PO/5/26/DOC

Address: St Johns Priory Poling Street Poling BN18 9PS

Proposal: Approval of details reserved by condition under PO/3/26/L relating to conditions 3- Pointing sample, 4- Brick wall sample and 5- Repairs methodology.

Re-pointing works

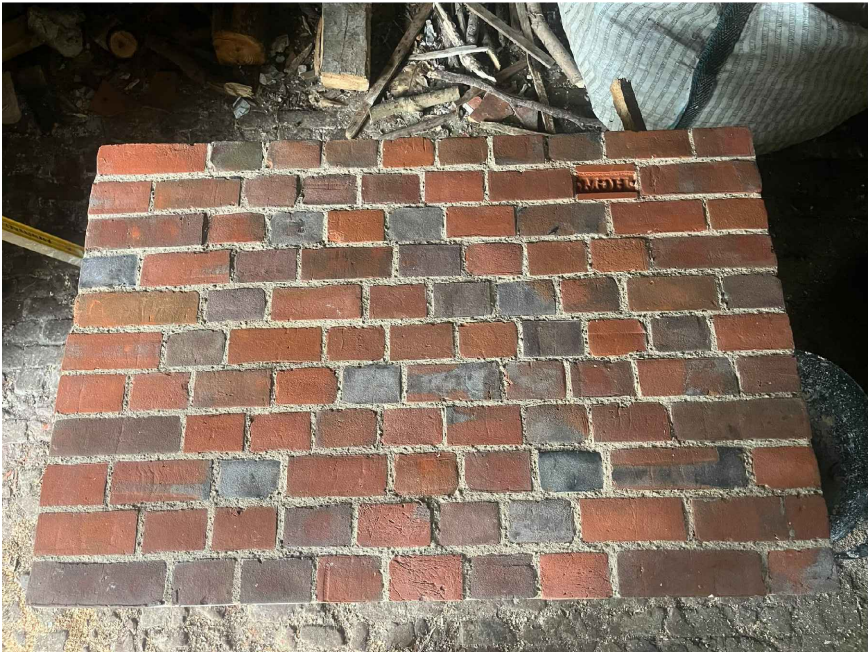
Condition 3: Pointing sample – whilst the details provided in the document look to be acceptable, I was not able to see a sample panel as stipulated in the condition. This needs to be prepared for inspection.
